City of Portland, Maine - Building or Use Permit Application
 389 Congress Street, 04101 Tel: (207) 874-8703, Fax: (207) 874-8716

Permit No: 07-1399	Issue Date:	CBL: 434 C002001
------------------------------	--------------------	----------------------------

Location of Construction: 281 VERANDA ST	Owner Name: ATLANTIC PROPERTIES LLC	Owner Address: 970 BAXTER BLVD	Phone:
Business Name:	Contractor Name: Donatello Builders Inc./Larry	Contractor Address: P.O. Box 684 Portland	Phone 2072327220
Lessee/Buyer's Name	Phone:	Permit Type: Additions - Commercial	Zone:

Past Use: Commercial - Office	Proposed Use: Commercial - Office - 62 Sq Ft addition & interior renovations to existing space	Permit Fee: \$490.00	Cost of Work: \$47,000.00	CEO District: 4
Proposed Project Description: 62 Sq Ft addition & interior renovations to existing space		FIRE DEPT: <input type="checkbox"/> Approved <input type="checkbox"/> Denied	INSPECTION: Use Group: Type	
		Signature: _____		Signature: _____
PEDESTRIAN ACTIVITIES DISTRICT (P.A.D.)				
Action <input type="checkbox"/> Approved <input type="checkbox"/> Approved w/Condition <input type="checkbox"/> Denied				
Signature: _____ Date: _____

#	DATE	DESCRIPTION
REVISIONS		
Date Issued	10/05/01	
Project Number	07113	
Drawing Scale	SCALE	
SHEET NAME		
FLOOR PLANS		
Drawn By		
Checked By	A-1.01

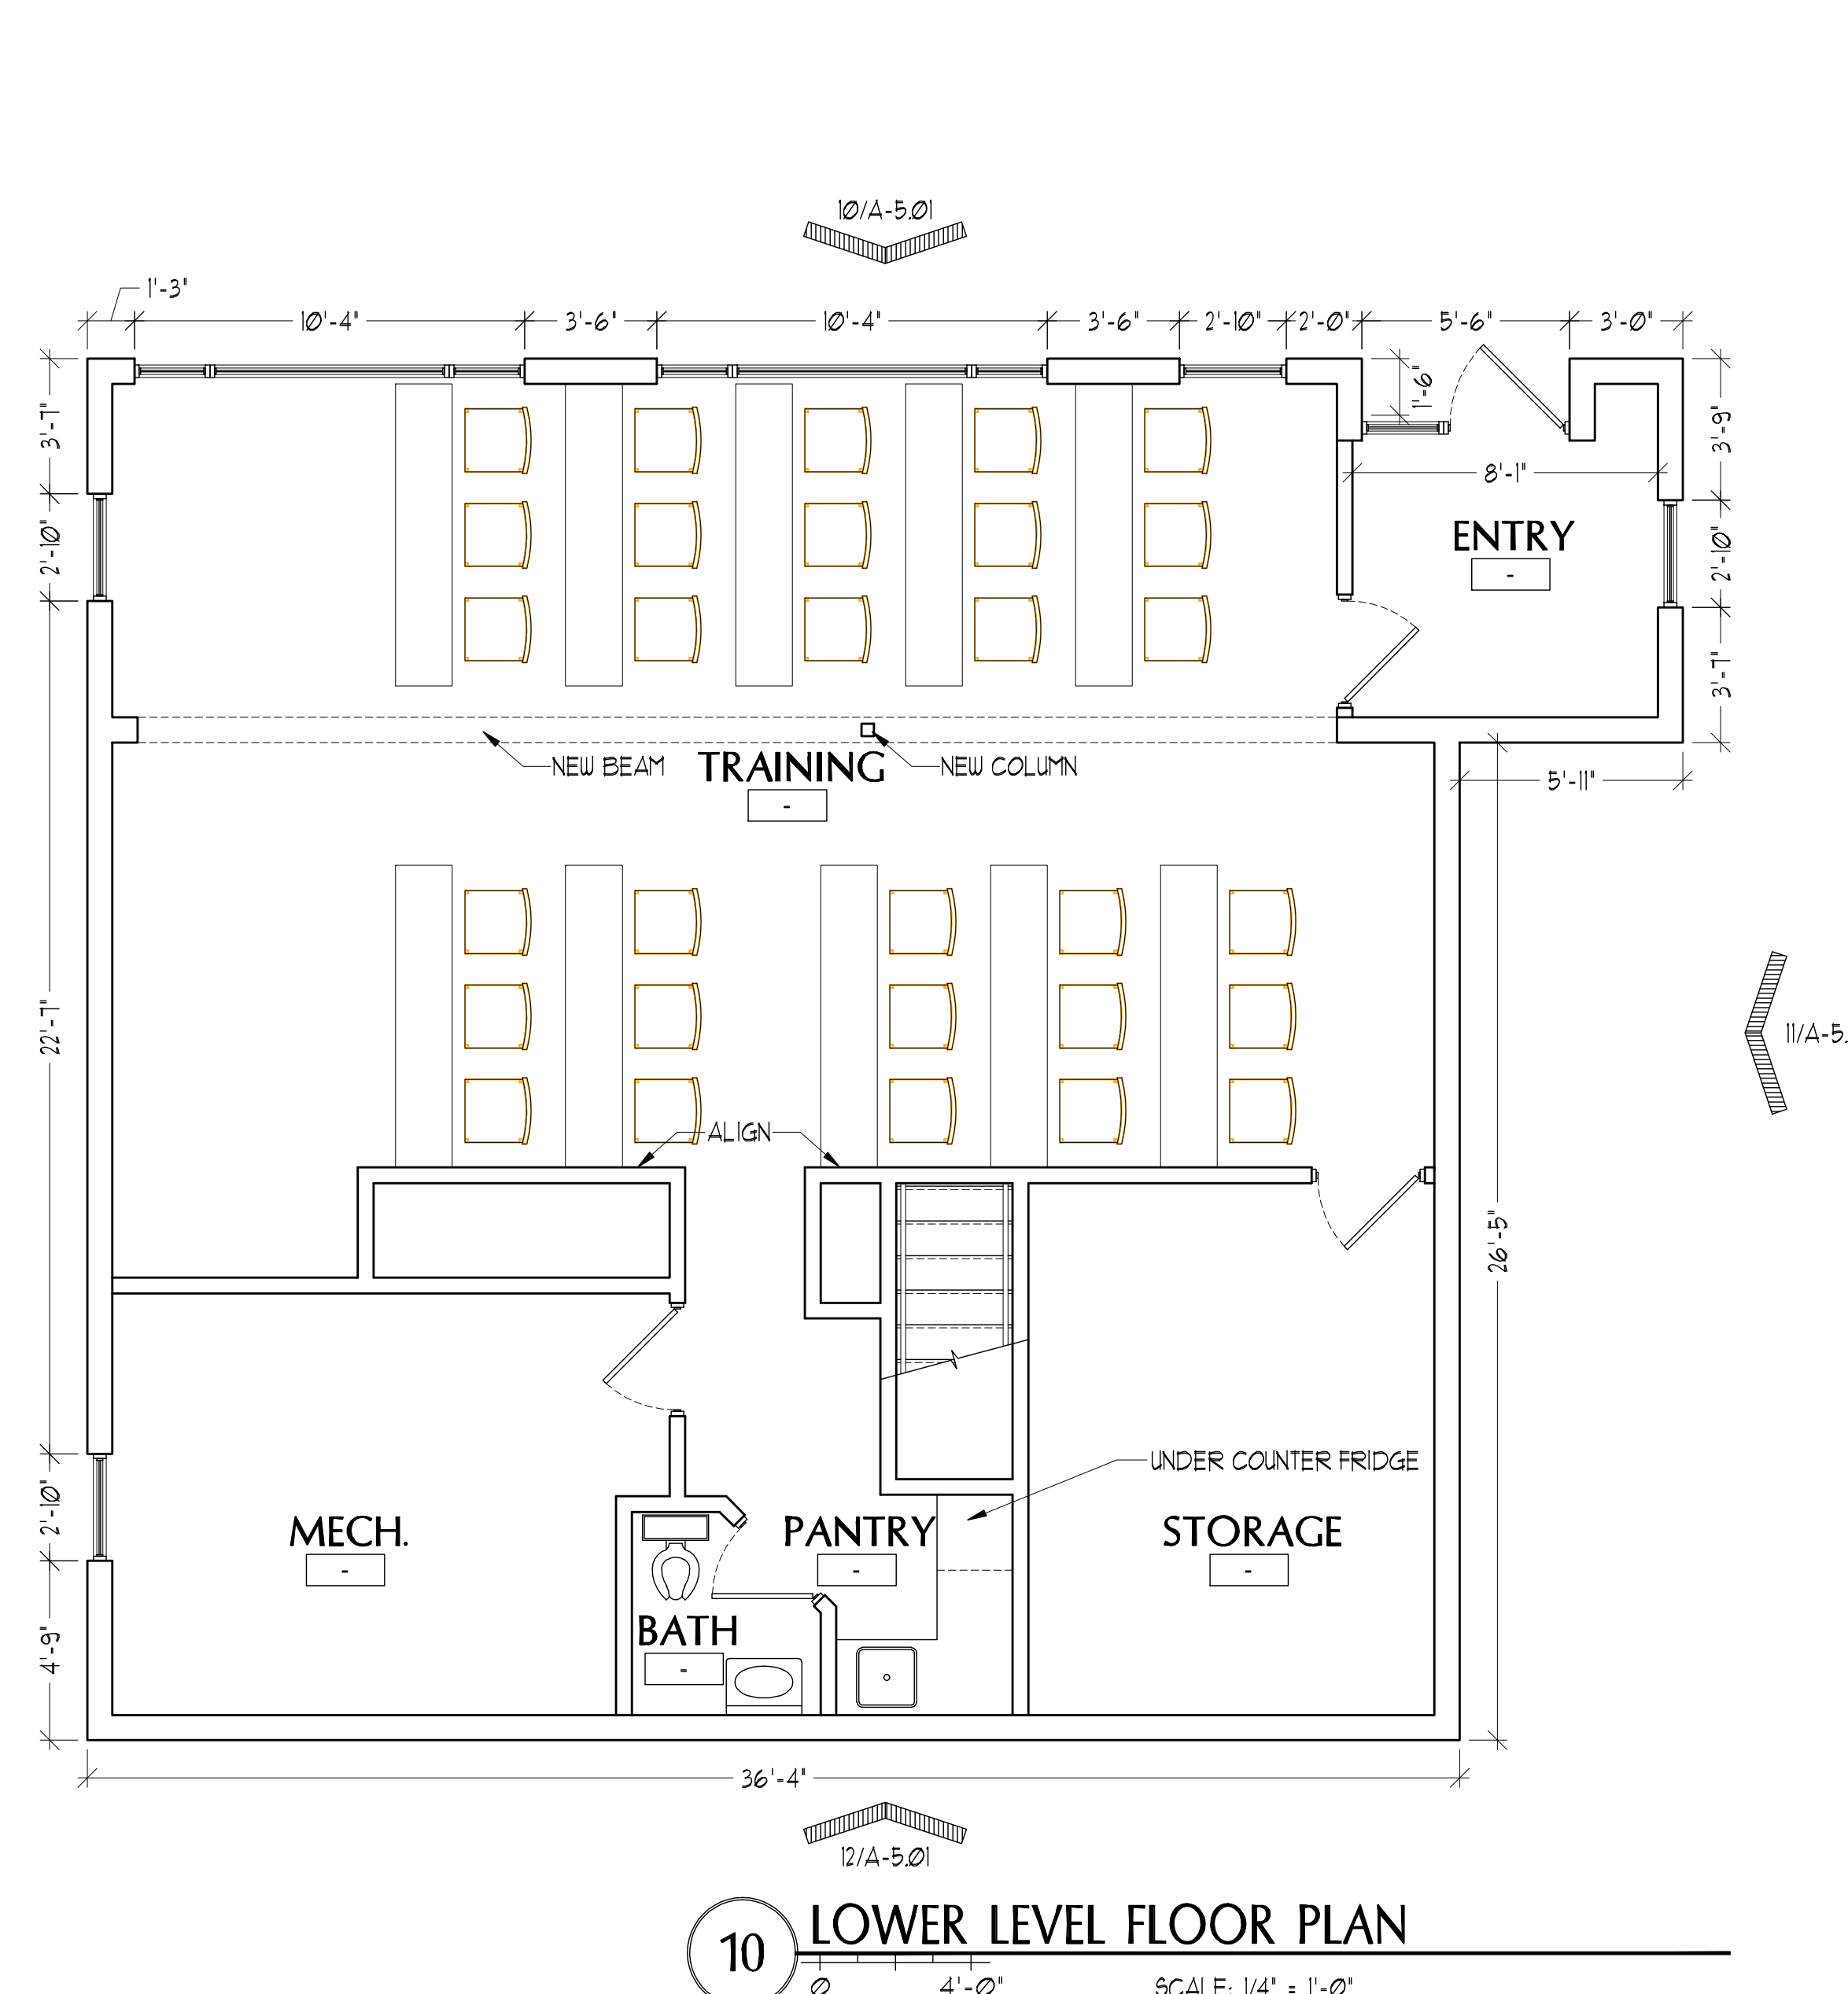
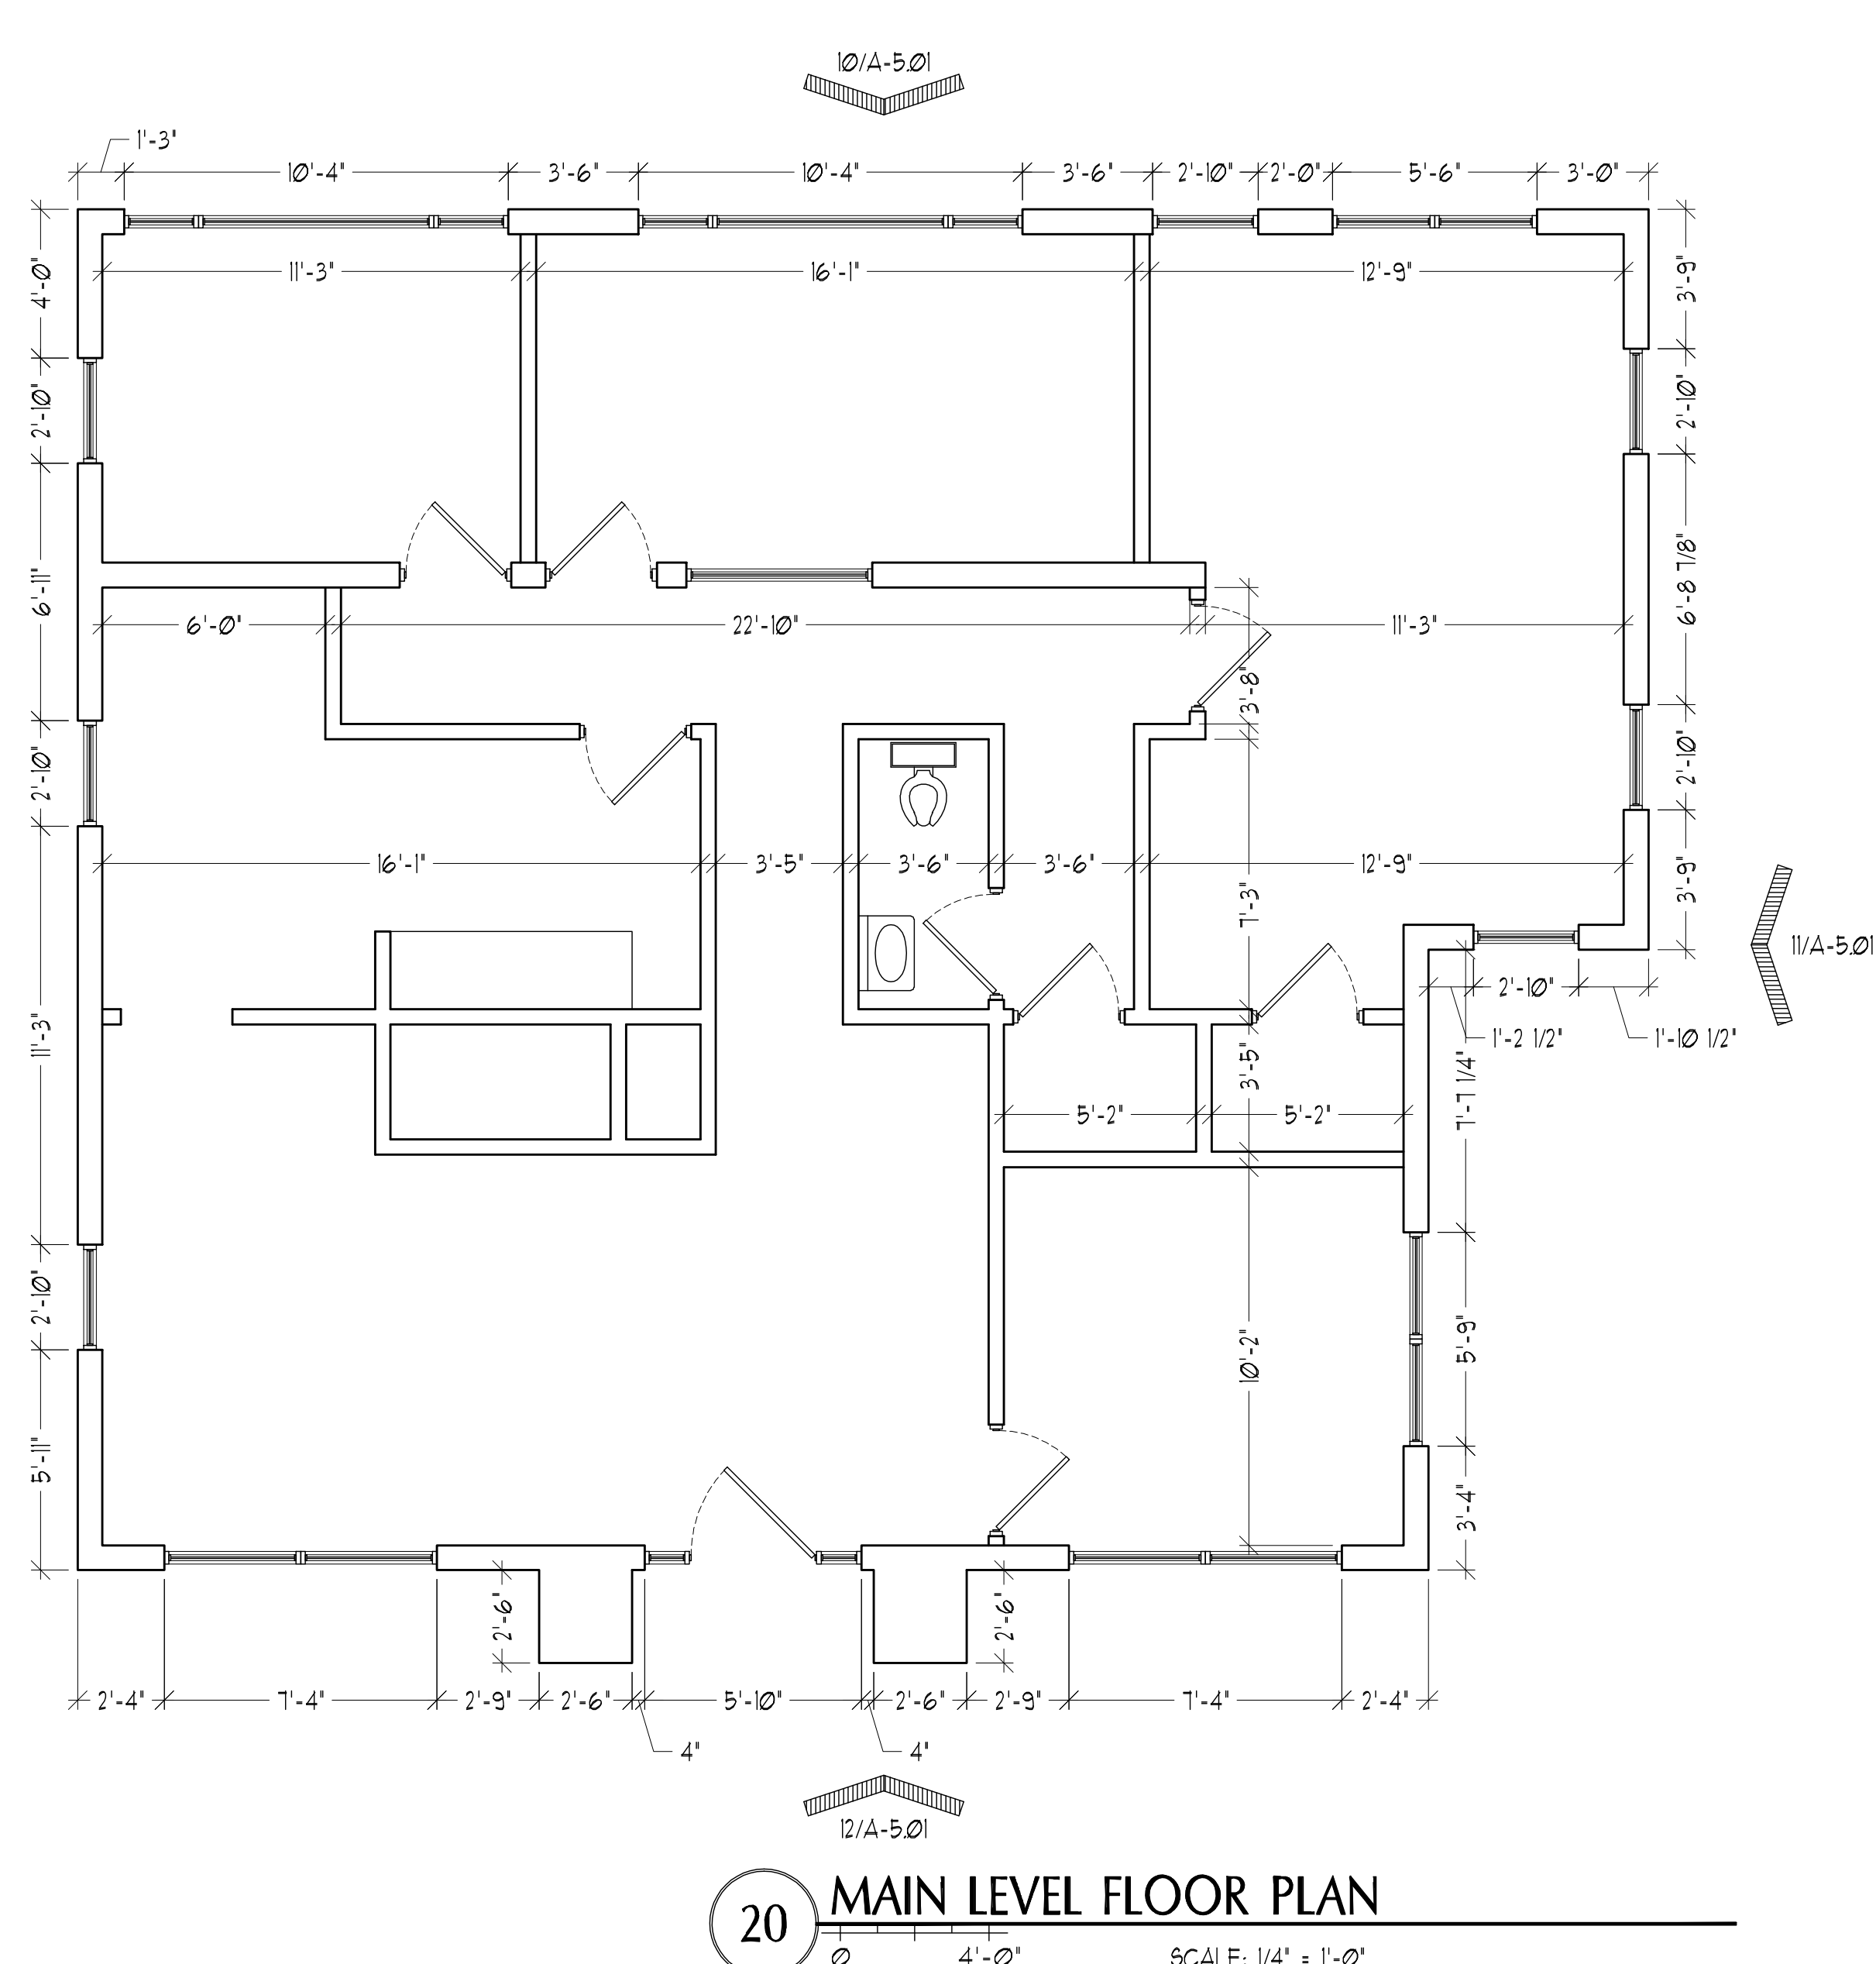
11/20/2007-amachado: Left message for Michael Banks. Are he and David Banks part of Atlantic Porperties, LLC. The application talks about a 62 sf addition. The plans do not show the addition except for the elevation plan.. They only deal with the remodeling of the existing building. If there is an addition, the property is in the shoreland zone so the 75' setback line from the highest sprnt tide needs to be located on the plot plan. Parking also need to be shown if there is an increase. Finally, need more specific use than business. It is R-P, need to know if tenant meets the permitted uses. Will need siteplan exemption.

11/27/2007-amachado: Spoke to Michael Banks. David Banks is the owner. The addition is on the plan. It is not a change of use because it is still a professional office (real estate). I told him that we need a survey that shows where the 75' setback is from the highest spring tide because the property is within the shoreland zone.
